**KIRKLEES METROPOLITAN COUNCIL
INVESTMENT & REGENERATION SERVICE**

Reference No:	2023/62/92262/W
Site Address:	61, Tanfield Road, Birkby, Huddersfield, HD1 5HD
Description:	Erection of single storey extension to rear (within a Conservation Area)
Recommending Officer:	Laura Yeadon

HOUSEHOLDER DELEGATED REPORT

Drawing:  
**Proposed Floor Plan**

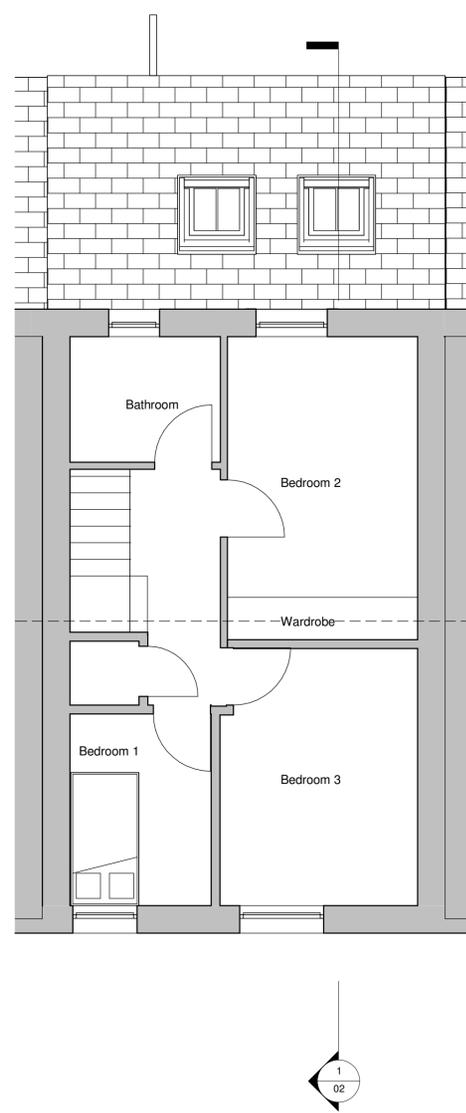
The proposed single storey extension would be located on the rear elevation of the property and would replace the existing outrigger which appears to be an original feature. The extension would extend the full width of the rear elevation at a projection of 4.5 metres with steps allowing access into the rear garden and to the basement area. The roof form would be a lean to roof for a projection of 3 metres with the additional 1.5 metre projection having a flat roof at a height of 3 metres. The proposed construction materials would be natural stone for the walls with a roof form to match the existing.

rear elevation street scene
not project out more than 3 metres from the rear wall of the original house for semidetached and terraces houses or by 4 metres for detached properties		No – the extension would project 4.5 metres which is 1.5 metres beyond the rear elevation of the attached property No. 63 and that recently approved at No. 59
where they exceed 3m in length the eaves height should generally not exceed 2.5 meters		No – the eaves would be approx. 3 metres due to the floor level of the property being higher than the external ground floor level
retain a gap of at least 1 metre from a property boundary, such as a wall, fence or hedge		No – – it would not comply with this however the property benefits from Permitted Development Rights and therefore could construct an extension up to the shared boundary at a projection of 3m without the requirement of planning permission (subject to criteria). To set the extension in from the side boundaries by 1 metre would significantly reduce the internal accommodation and would result in an appearance which would not be in keeping with the street scene

Drawing
Proposed Elevation

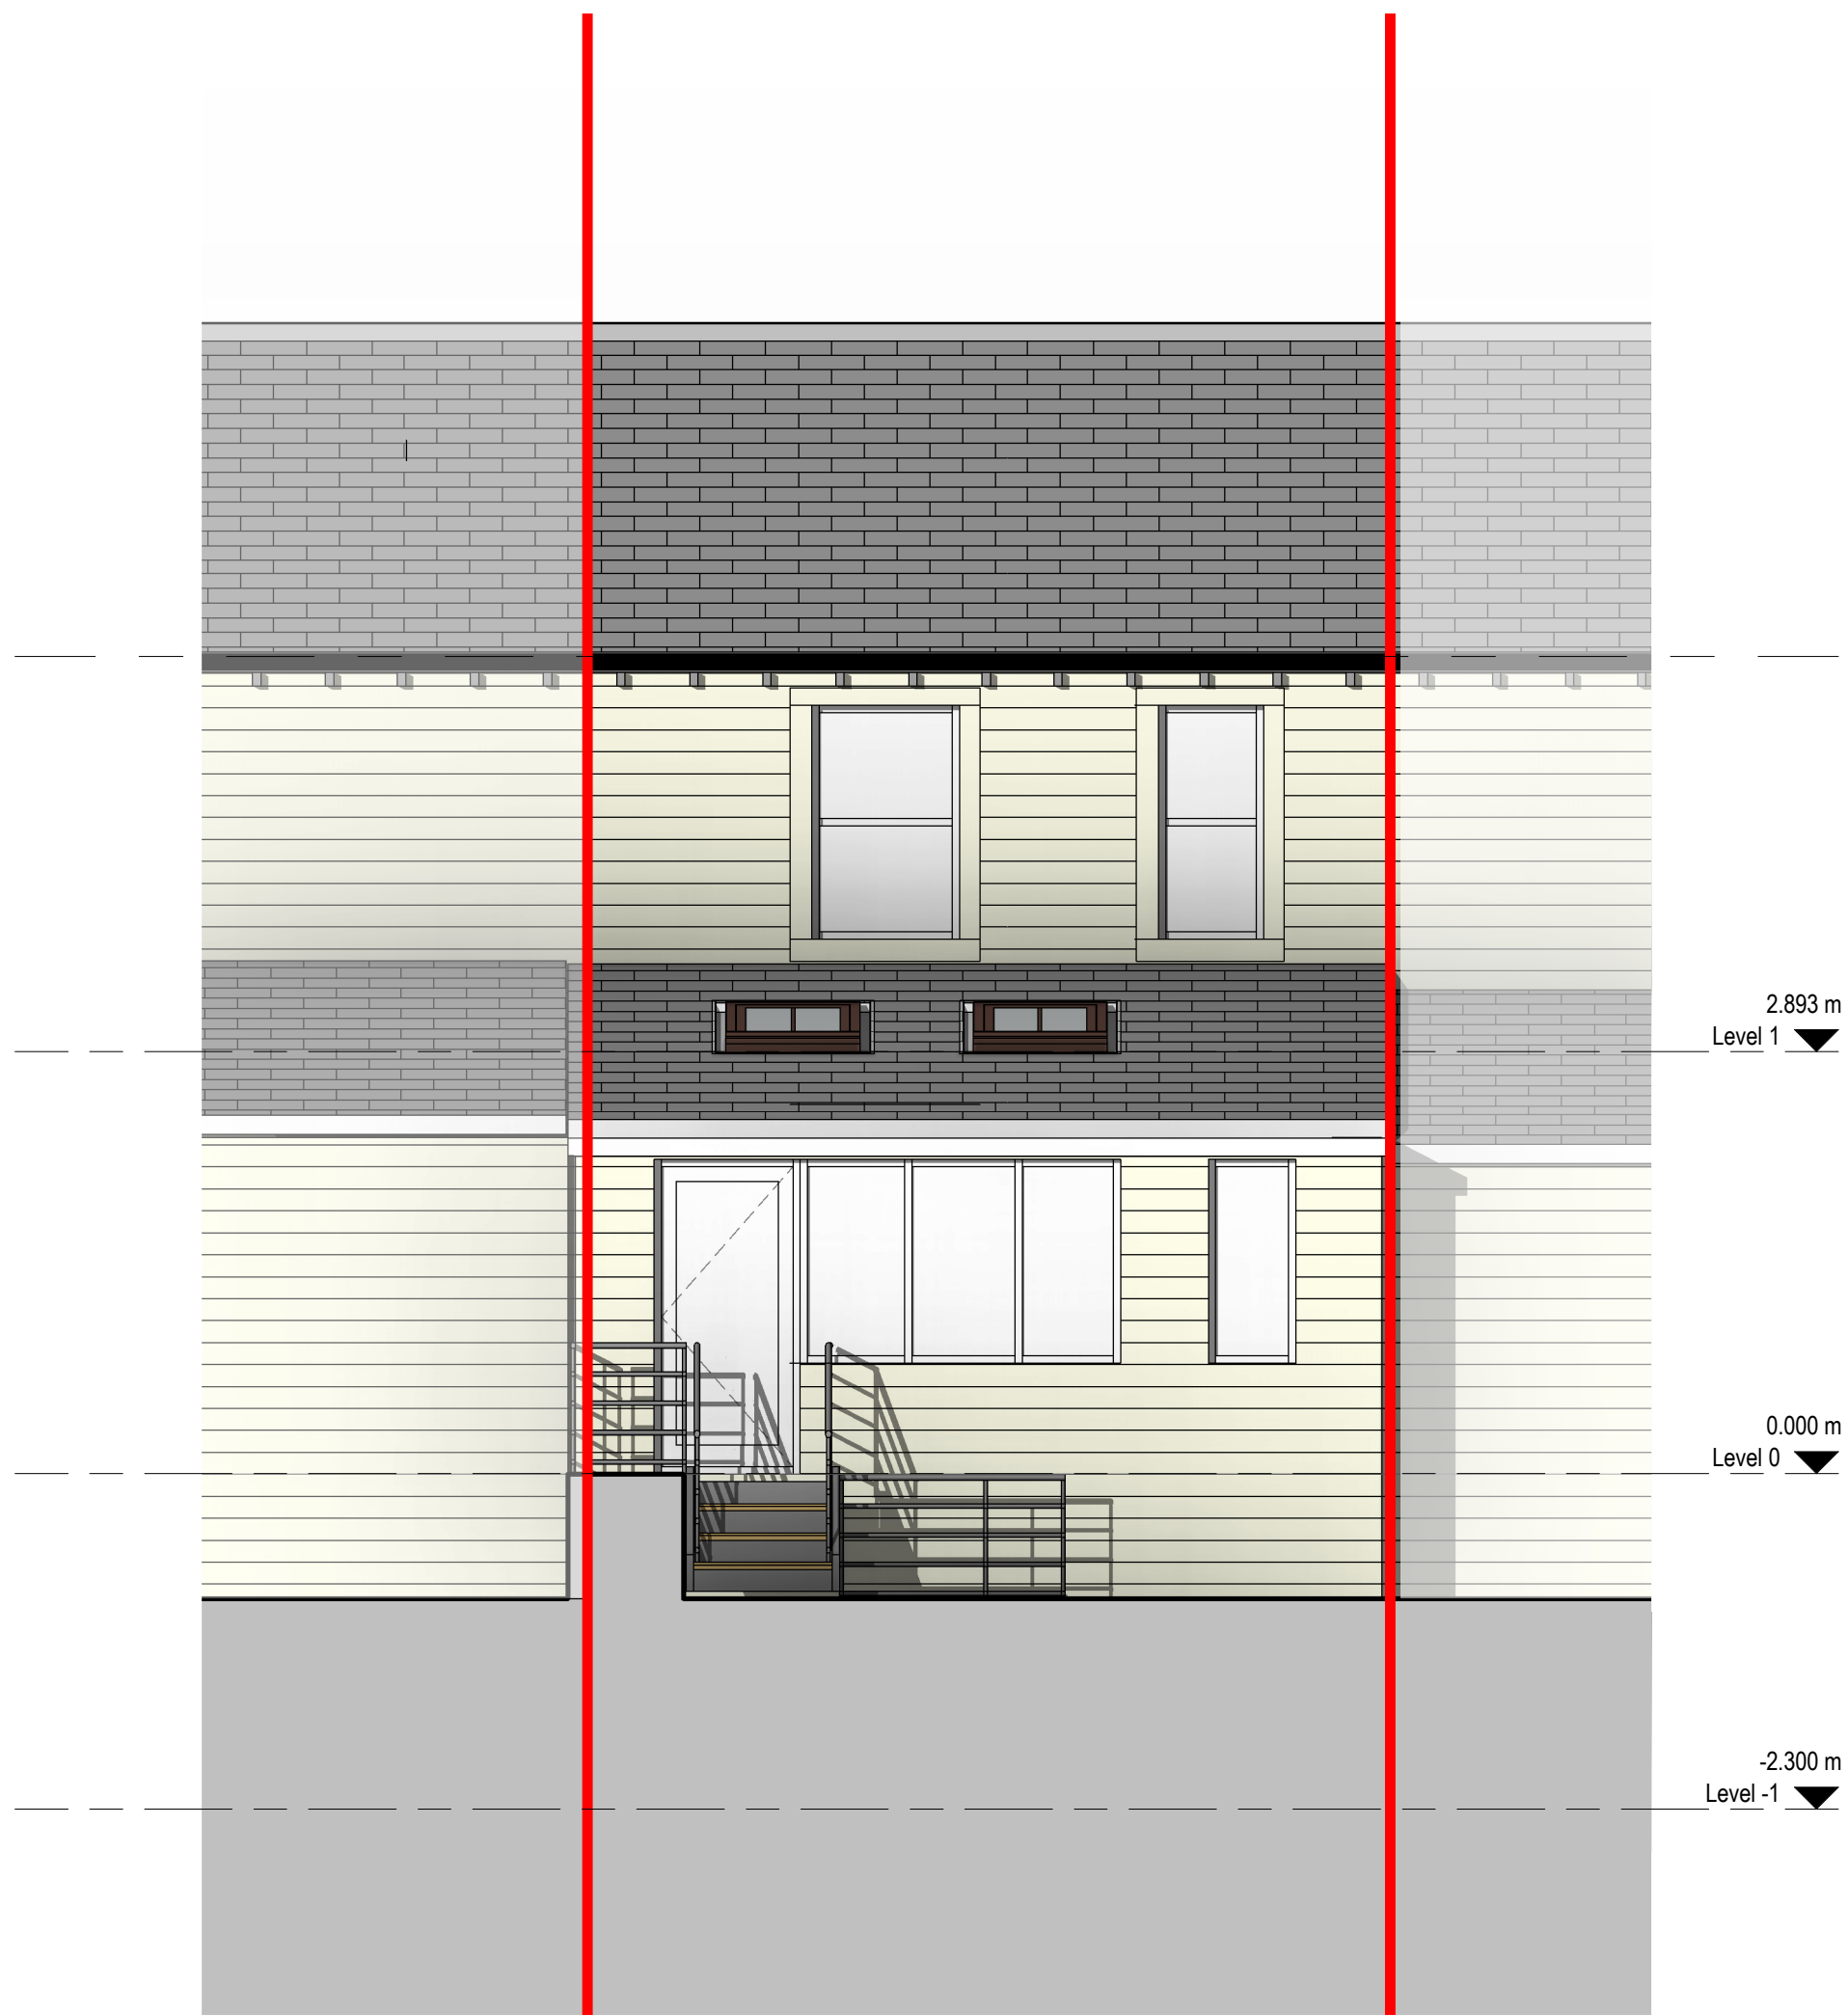
YES / NO	SUMMARY
Negotiations/Amendments during course of application	Yes	The application was submitted with a large rear dormer extension. Due to the impact of the proposal on the Conservation Area and also being in direct line of the nearby Grade II* Listed Church, it was considered that the dormer would harm the setting of the Church by adding a large flat roof

structure to the roof scale. It was therefore requested that the rear dormer was omitted from the scheme. Amended plans were submitted which omitted the dormer on 9 th November 2023
Parish/Town Council comments sought	No	N/A
Planning History	N/A	No history
Consultations required	Yes	Conservation and Design – informal comments – no objection to single storey extension subject to construction materials being natural stone and roofing materials to match – object to dormer as it is directly in line with Grade 2* Church which is of high significance - direct view from back lane - almost all traditional pitched roofs remain in historic form which would harm setting by adding large flat roofed structure which would be discordant with character of roofscape and not harmonise with its current and historical form

not normally cover more than half the total area around the original house (including previous extensions and outbuildings)	It would comply with this criteria	
not exceed 4 metres in height		No – the extension would be at total height of 4.3 metres however this is due to the floor level of the property being higher than the external ground level – similar in height to other extensions within the

Facing materials and detailing	<ul style="list-style-type: none"> • KDP 9 of the SPD • Policy LP24 Design (d) (iii) of the KLP • Chapter 12 of the NPPF 	Material are to match	✓
Roof style	<ul style="list-style-type: none"> • KDP 1 and 2 of the SPD • Policy LP24 Design (a), (c) 	Part flat and part lean-to roof style – as in the main part this would be a lean-	✓

The application was submitted with a large rear dormer extension. Due to the impact of the proposal on the Conservation Area and also being in direct line of the nearby Grade II* Listed Church, it was considered that the dormer would harm the setting of the Church by adding a large flat roof structure to the roof scale. It was therefore requested that the rear dormer was omitted from the scheme. Amended plans were submitted which omitted the dormer on 9th November 2023
